**Application Reference:- M/133/17/PL**

**'Demolition & erection of 1 No. dwelling to existing ground floor slab  
Little Thatch, 93 Middleton Road, Middleton on Sea PO22 6DW'**

SOUTH ELEVATION

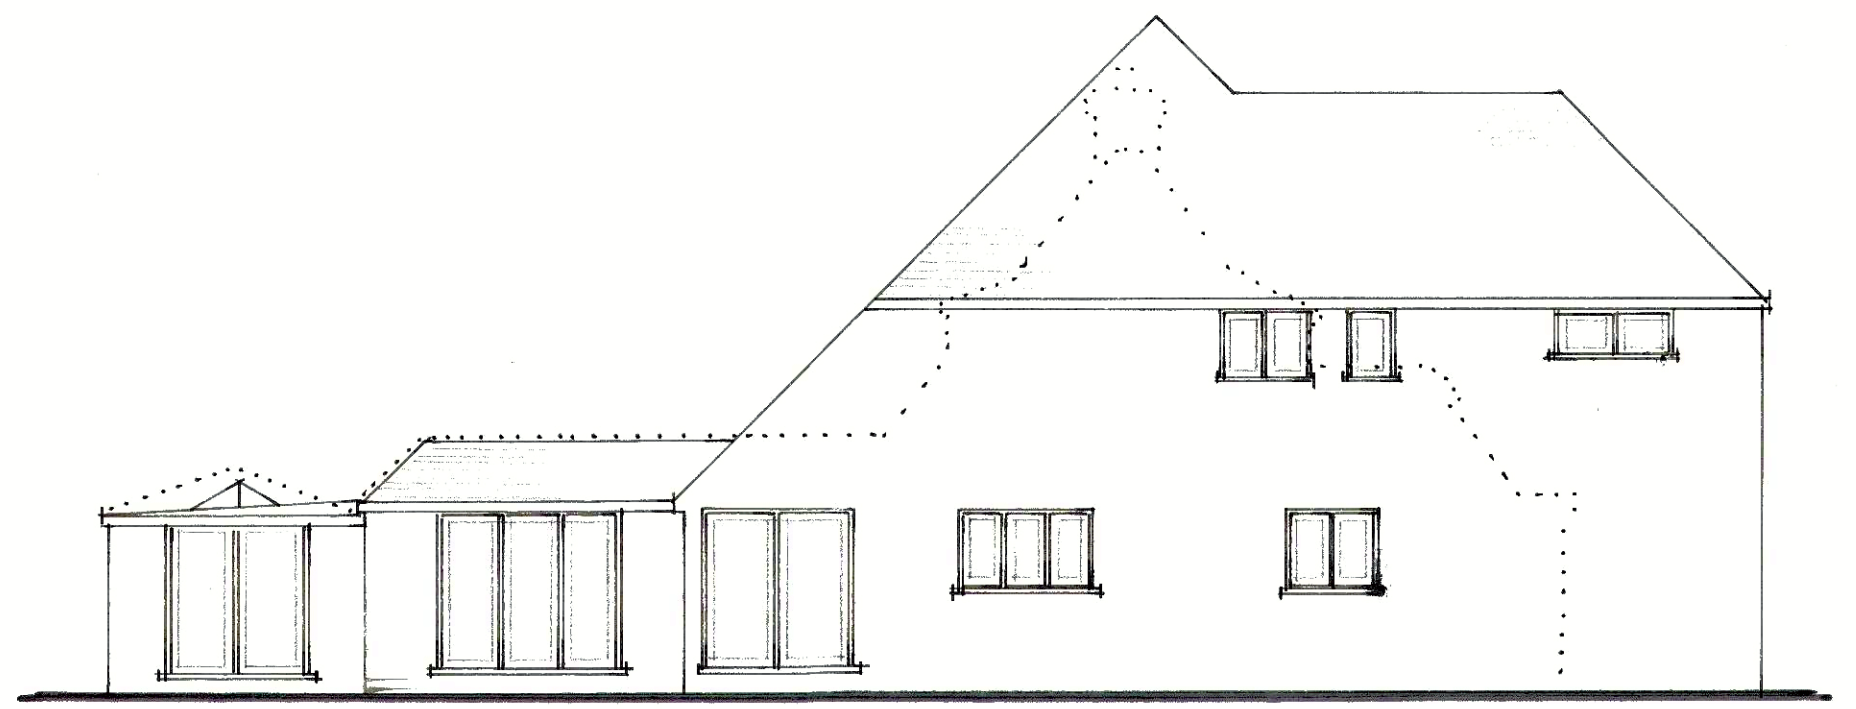
The proposal involves a new building which would have a roof ridge substantially higher than the one which currently exists. However, due to the presentation of the plans, we are unable to ascertain the increases in height (eaves and ridge) and this prejudices our opportunity to comment in full.

We would also like to highlight that the rear doors on the orangery don't seem to tie up when looking at the rear elevation drawing and the ground floor plan.

EAST ELEVATION

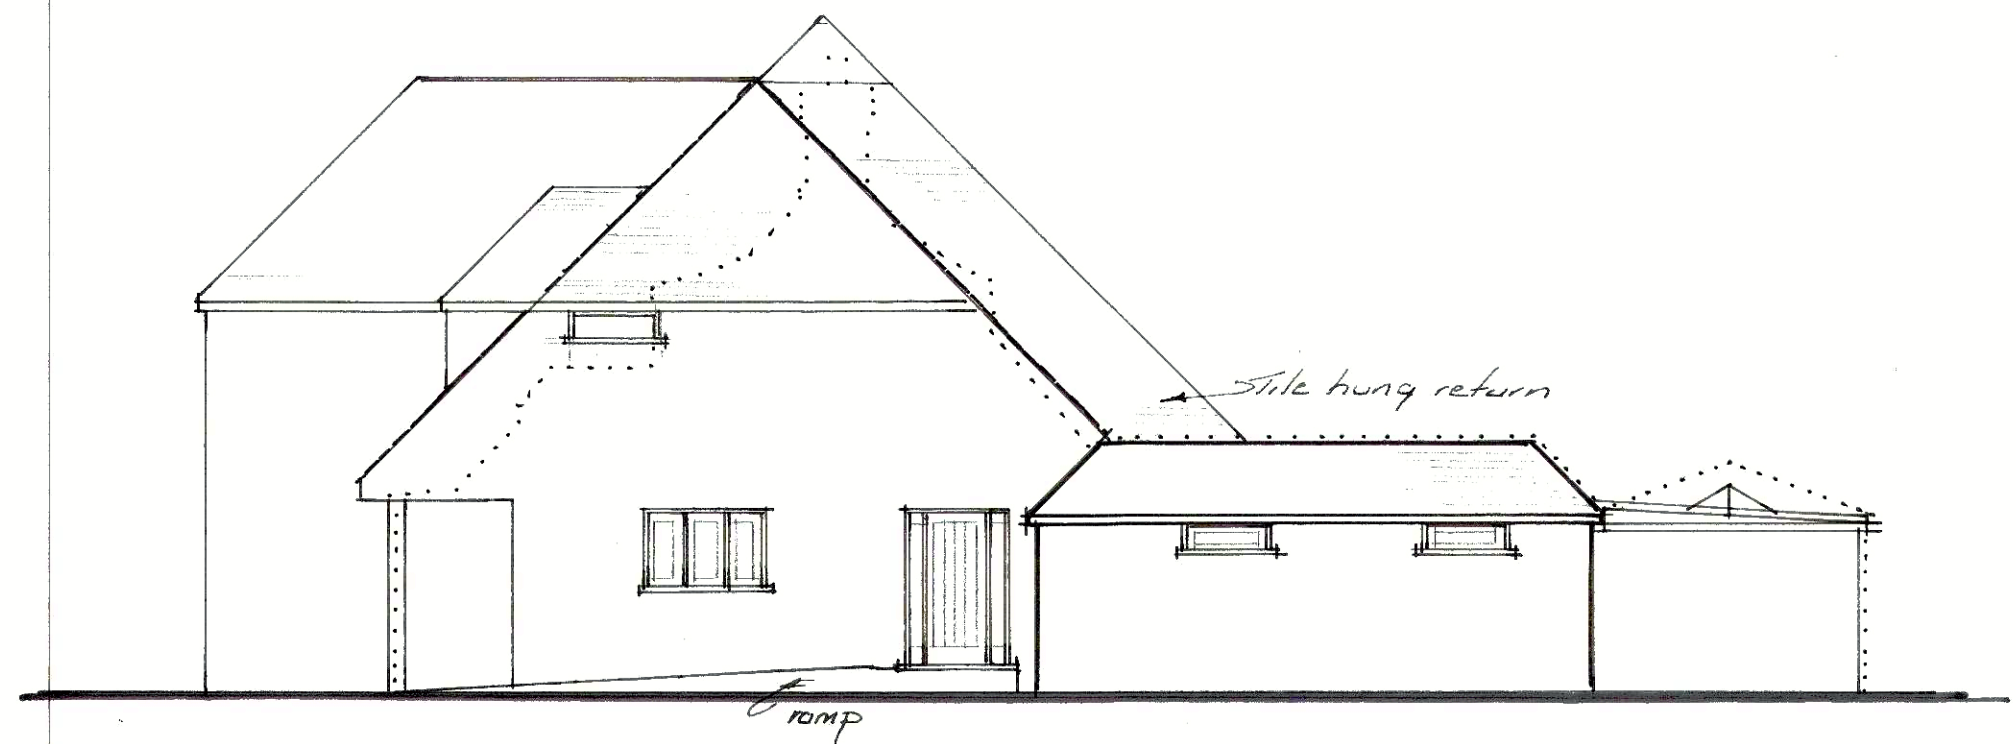
Focusing on the elevation facing our property, the configuration of the roof would look bulky and particularly awkward. The substantial increase in the height of the side elevation, as well as the eaves and ridgeline of the roof itself, would be particularly dominating. The new two-storey house that be built would have an over-bearing presence on us, resulting in a loss of outlook and light levels, especially in the afternoon during the months when the sun is lower in the sky.

Currently there are only ground floor windows facing us at no. 93, hidden behind the fence (which is not acknowledged in Section 15 of the Application Form). The proposal includes three more windows above on the upper levels. The two rooflights would serve Bedroom 4 and the stairway area leading to it. Neither of these appear to be necessary and we consider them to be un-neighbourly. The window serving the un-named room (which is actually simply the en suite end of the bedroom) is also un-neighbourly and adds to the presence of being continually overlooked. We are also concerned that an alternative internal layout (which wouldn't be subject to Planning permission) could exacerbate the loss of privacy in the future.

- (1). The bedroom window on the east elevation be replaced with a sky light similar to the one at the other end of the room. This will still let good sunlight into the room but won't then overlook our private seating area.□*

- (2). The roof light in the hallway be replaced by glazing around the new entrance door, or if a roof light must be fitted, for it to be fitted with the highest level of obscurity and severely limited in size to sustain the privacy into our kitchen diner and private seating area.□*

- (4) A condition is imposed which prohibits any additional fenestration / glazing on the east elevation (or amendments to those shown on the drawings).*
